Engineers Comments Regarding Surface Water Drainage

Application Reference:	P/107/25/DOC	Reviewer Reference:	ADC/EXT4
Planning Officer:	Jessica Riches	Date of Review:	31/10/2025
Site Name:	Land West of Hook Lane Pagham PO21 3PB		
Application Description:	Approval of details reserved by condition imposed under P/149/23/S73 relating to condition 9 c) surface water drainage.		
Assessment Number:	2 of 2

Response	Condition 9 C: Objection
-----------------	---------------------------------

TYPICAL INSPECTION CHAMBER DETAIL

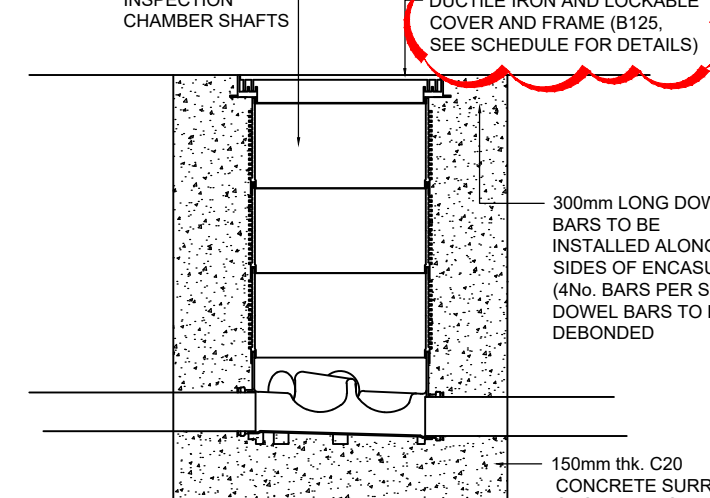
p) The Typical inspection chamber detail appears to show a light duty cover which contradicts the manhole schedule Provide revised drawings and calculations that are coordinated and consistent	P. Inspection chamber covers are not shown on the Manhole Schedules. Updated Drawings & Calculations.

TYPICAL SECTION ALONG ATTENUATION SYSTEM (REFER TO DRAWING C016)

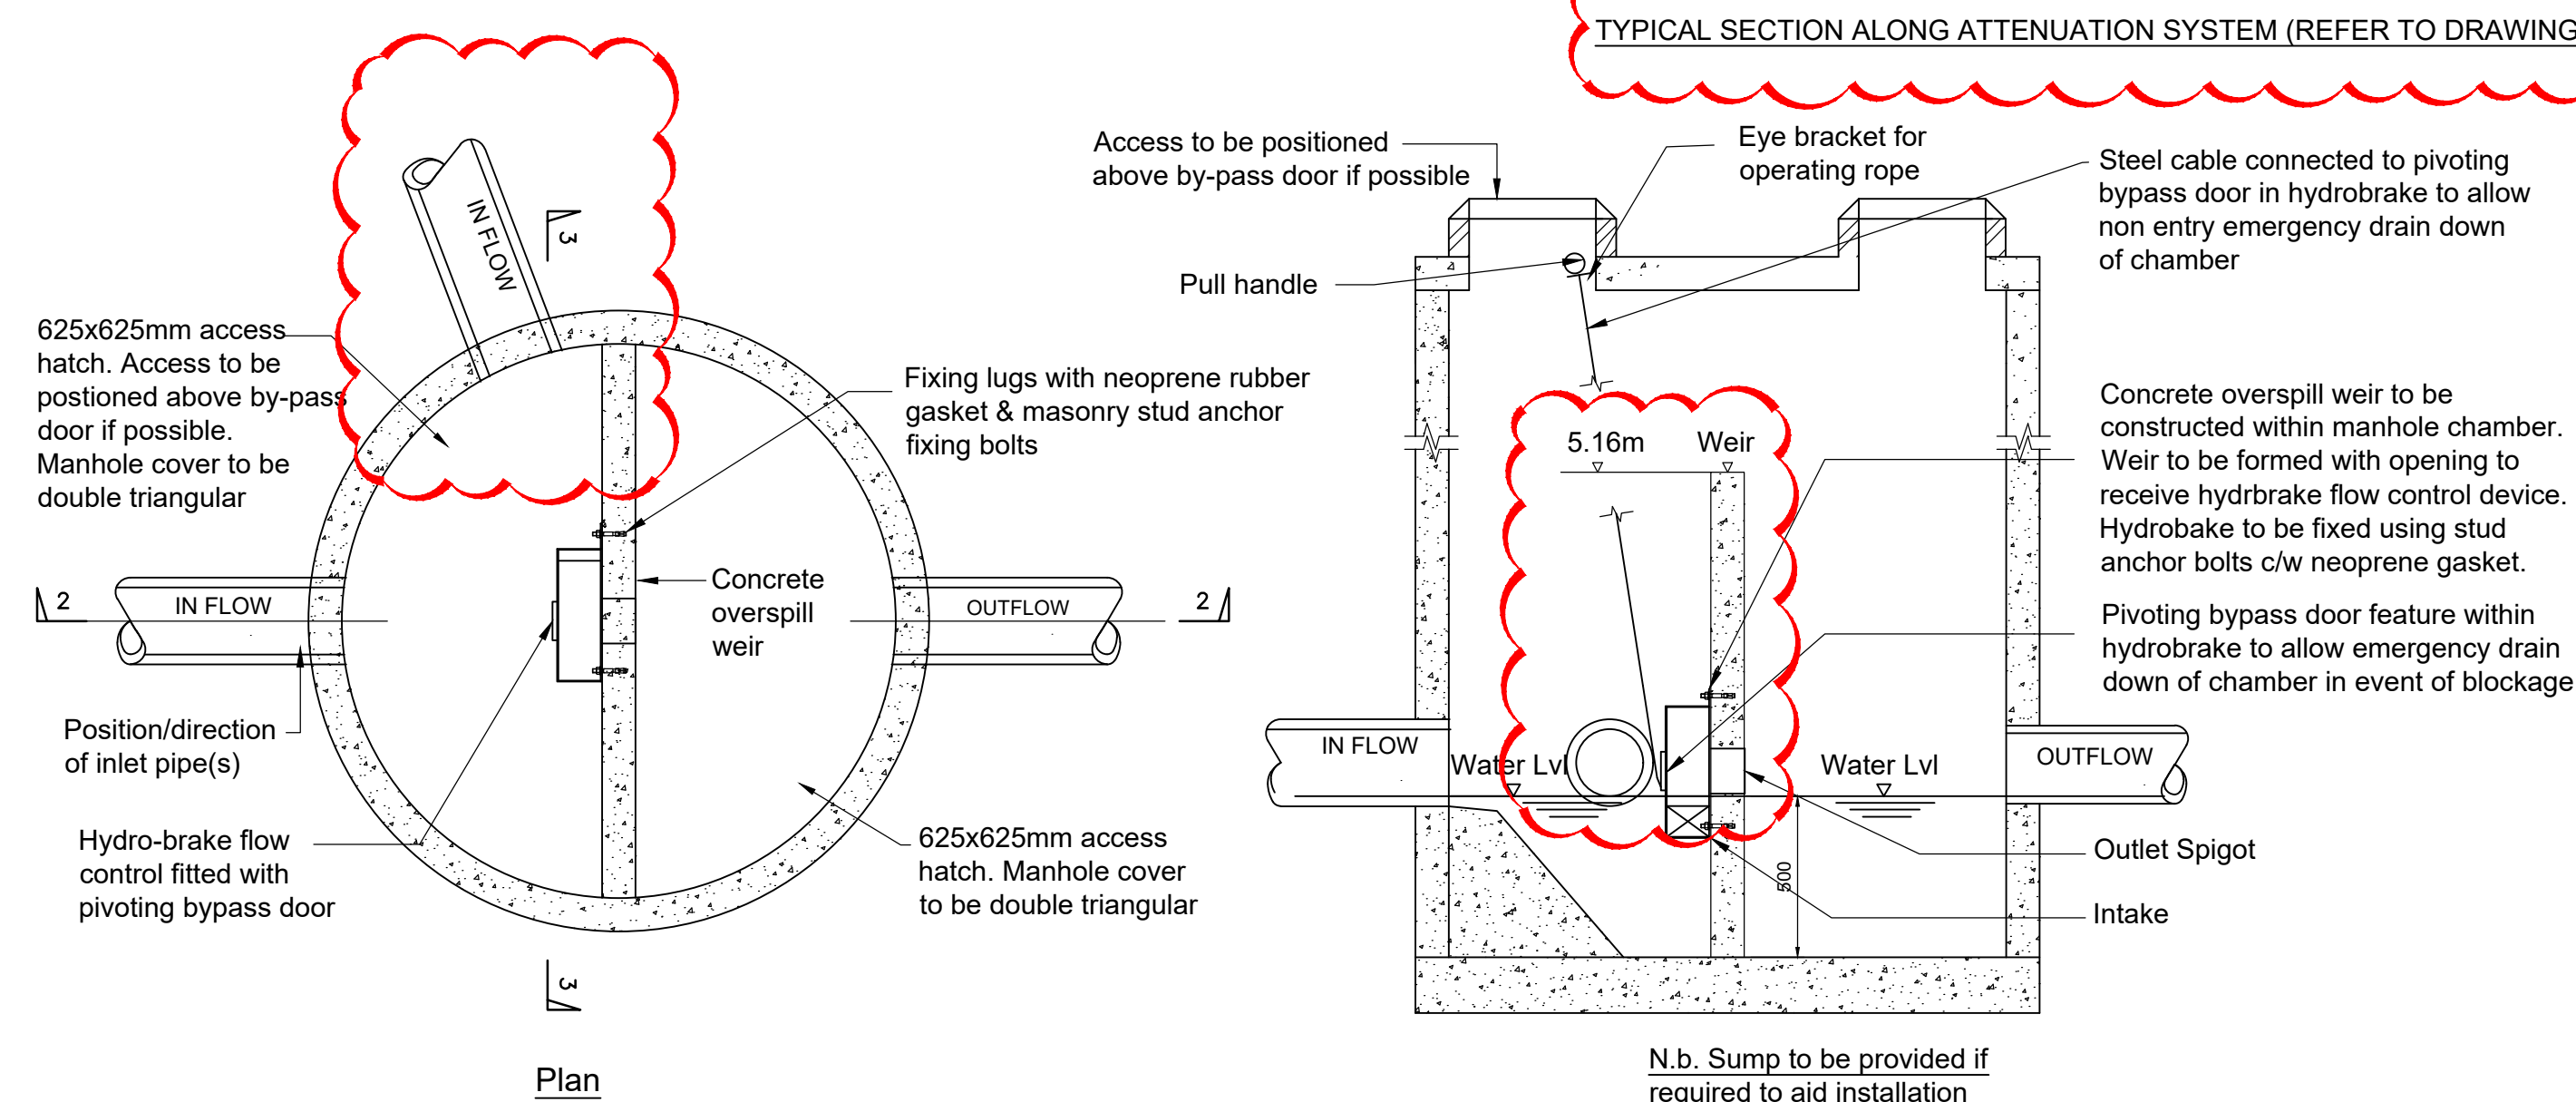
6)	The drainage construction details are not consistent with the others plans and the calculations. a) The tank detail shows a manifold arrangement for the tank connections, the plan shows a single pipe b) The tank detail shows catchpits upstream and downstream of the tanks, they are not shown on the plan or manhole schedule c) The volume stated for tank ST2 is not consistent with the plan	A These details were provided in Rev C. calculations. Updated Drawings & Calculations. B. These were provided in Rev. C calculations. Updated Drawings & Calculations. C. This was provided in Rev. C calculations. Updated Drawings & Calculations.	A. The tank detail on drawing 9418-C003-H still indicates conflicting information. The plan section indicates 2x 225mmdia. Or 3x150mm dia pipes whilst the section indicates a 300mm

GRAF ECOBLOC MAXX STORAGE SYSTEM (ST1)
(21.6x2.4x0.61m - 30.04m³)

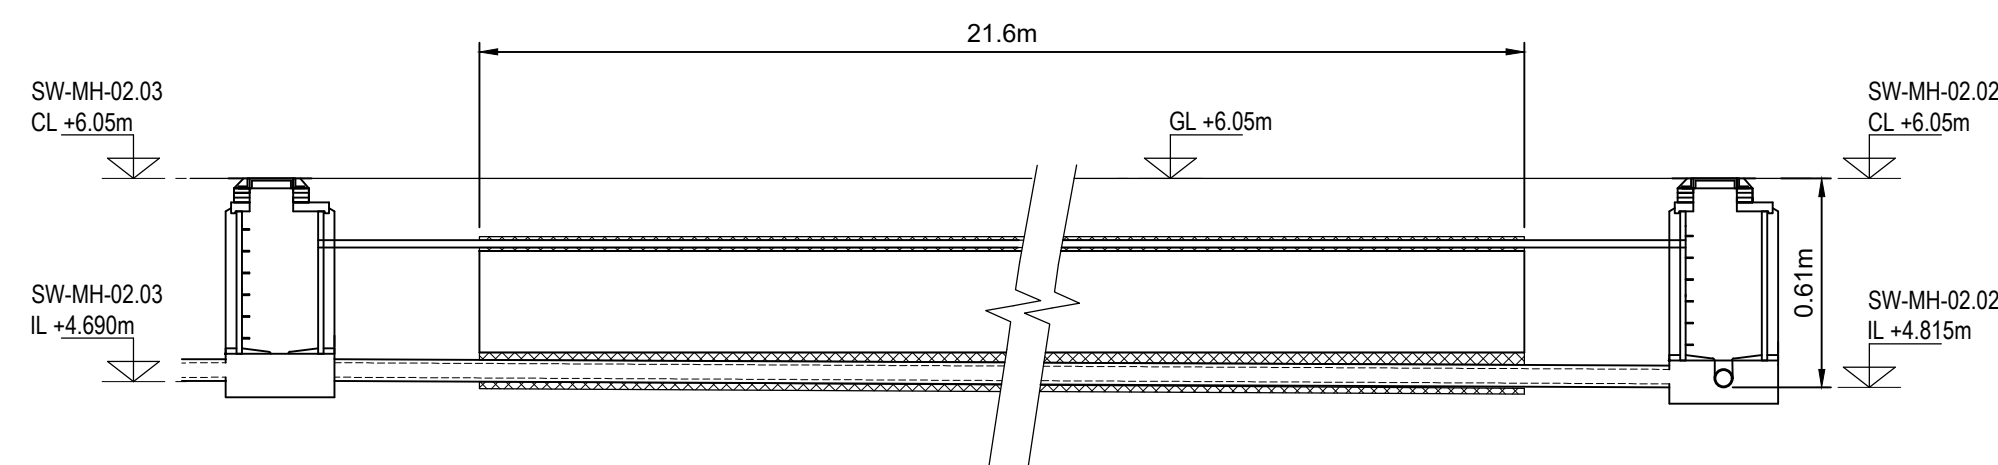
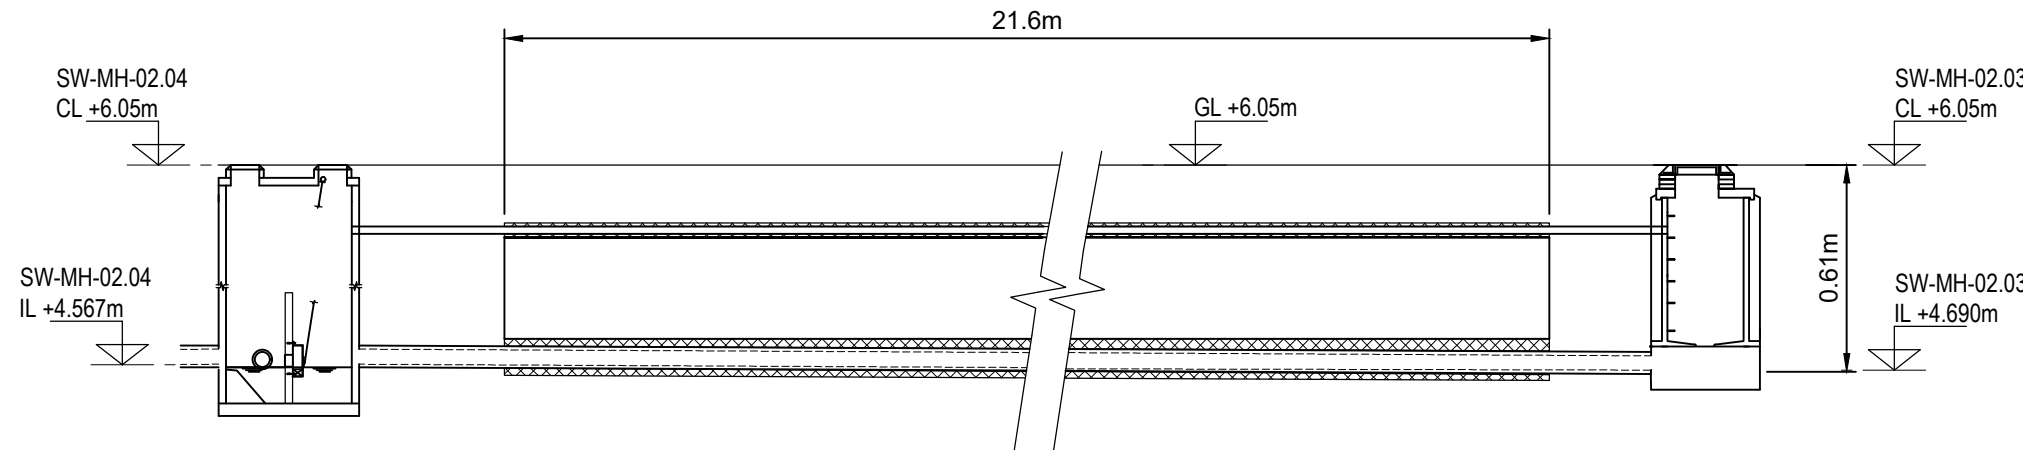
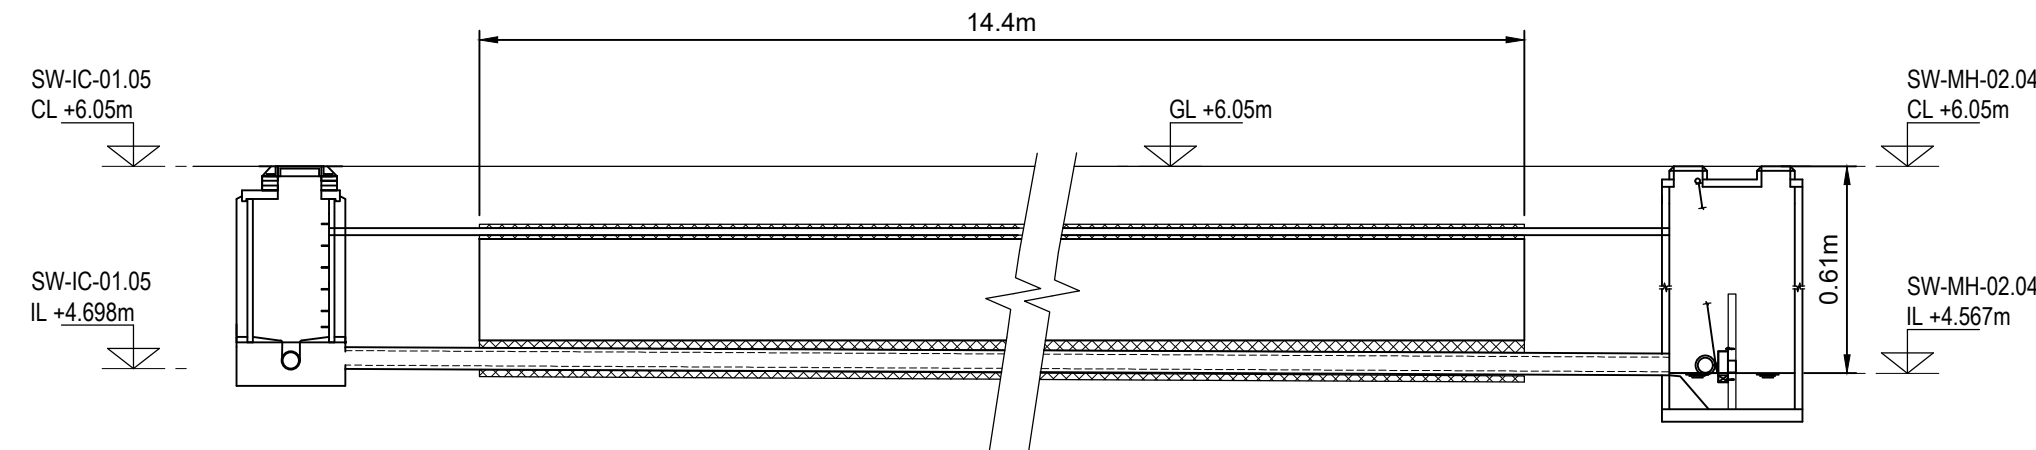
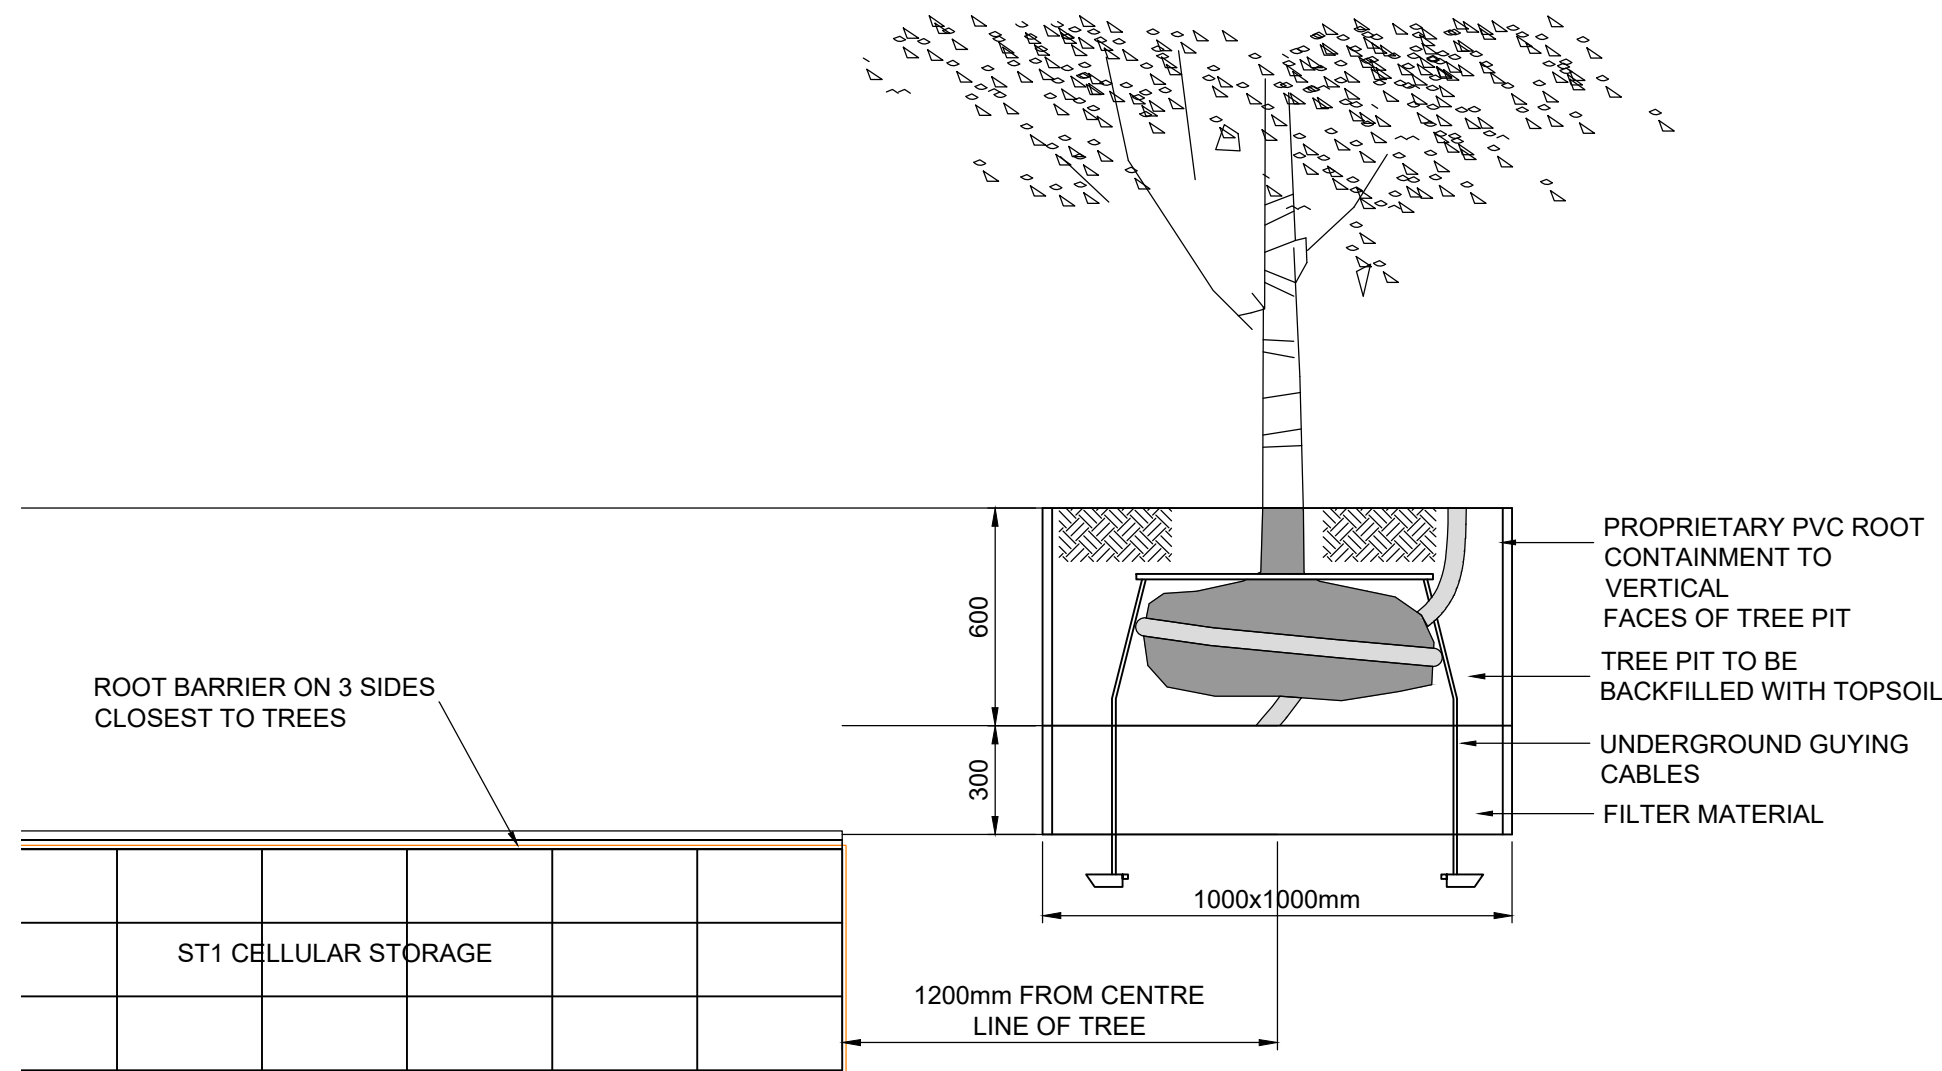
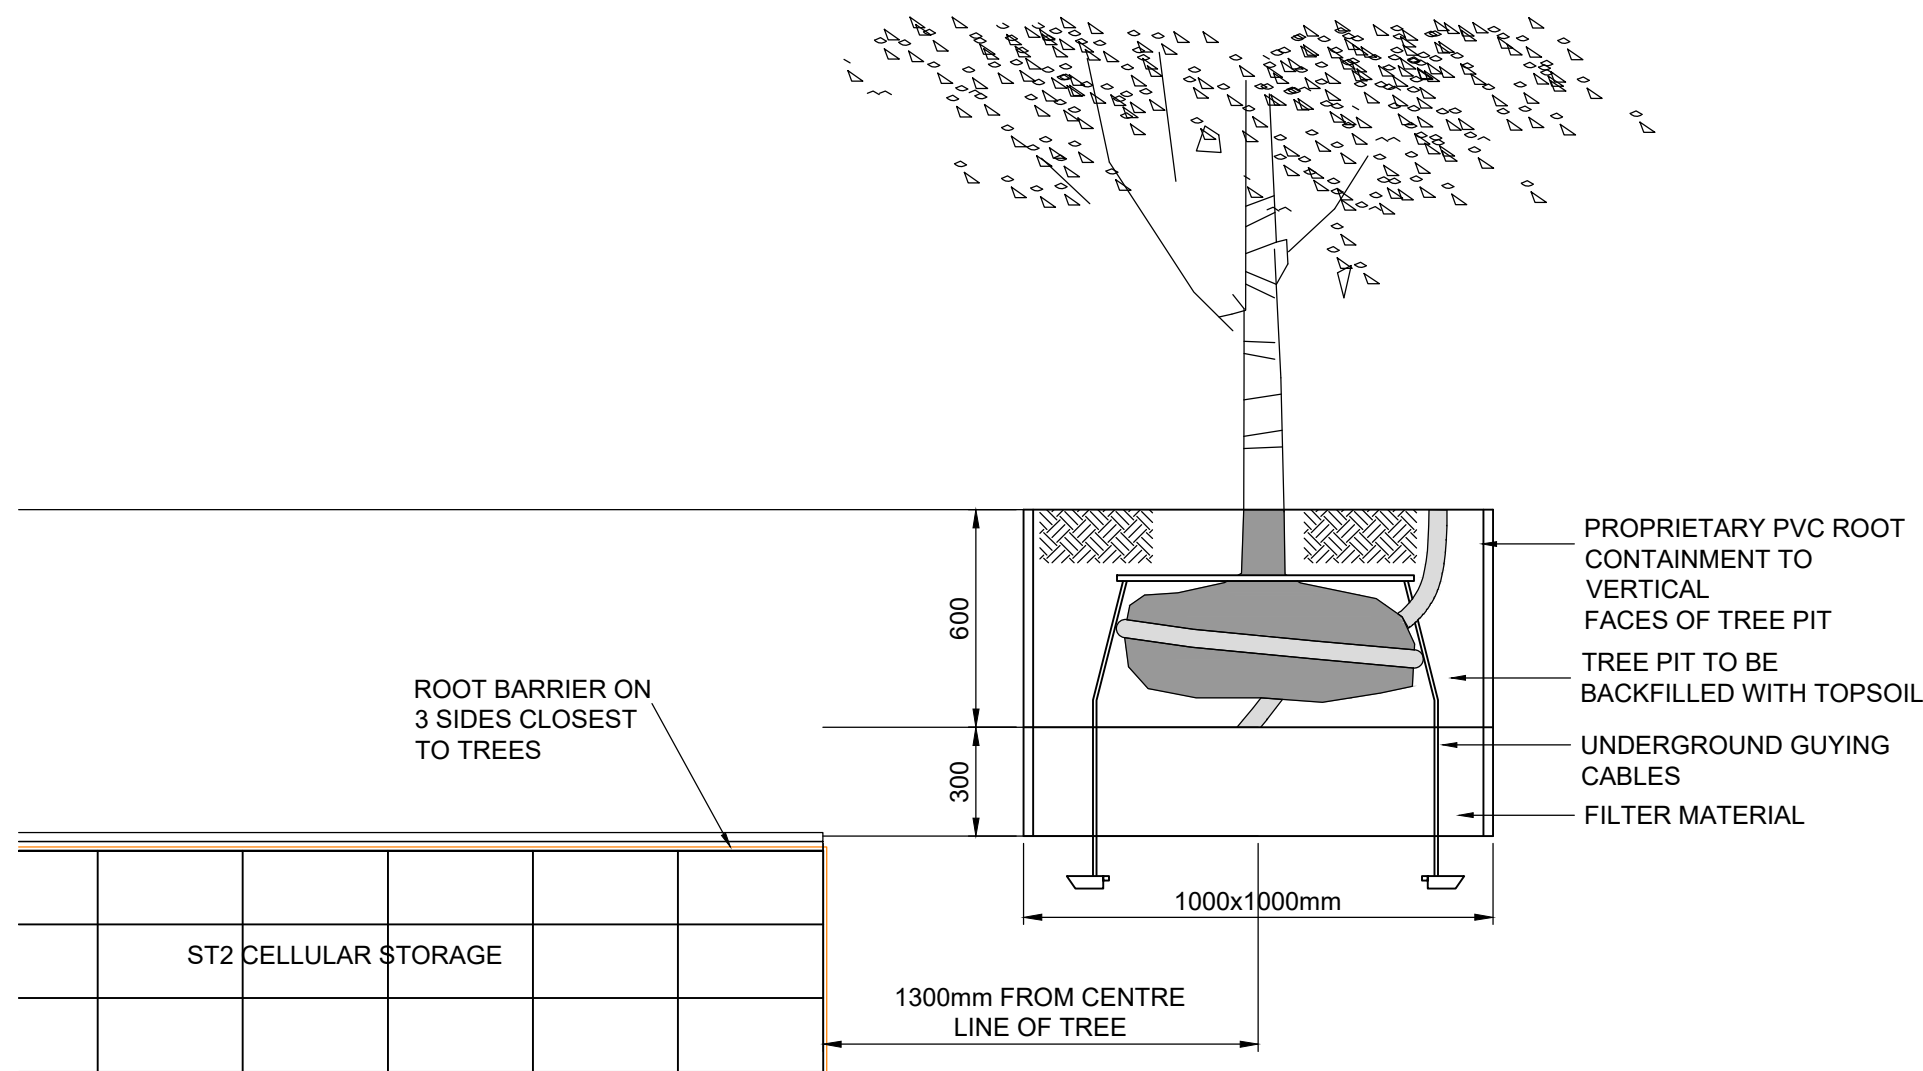
a) The indicative landscape proposal drawing shows a tree very close to tank ST1. Section A-A provided does not appear to represent this.  b) Provide information from the root barrier manufacturer and the tank manufacturer that the proposal is acceptable. c) Demonstrate that the tanks are structurally sufficient given the close proximity of the trees. d) Provide accurate cross sections showing that there is adequate space for the building foundations, foul and surface water drainage pipes, tree pits e) Demonstrate that the roots of the trees planted close to the permeable	A. Rev C Calculations - Updated Drawings & Calculations. B. See Appendix G. C. See Appendix G. D. Updated Drawings & Calculations. E. See Appendix G.	f. item now closed g. (New Item) there appears to be clashes on the proposed drainage runs and trees SW-IC03.01 to SW-MH-02.01 and SWIC-01.03 to SW-IC01.04		
--	--	--	--	--	--
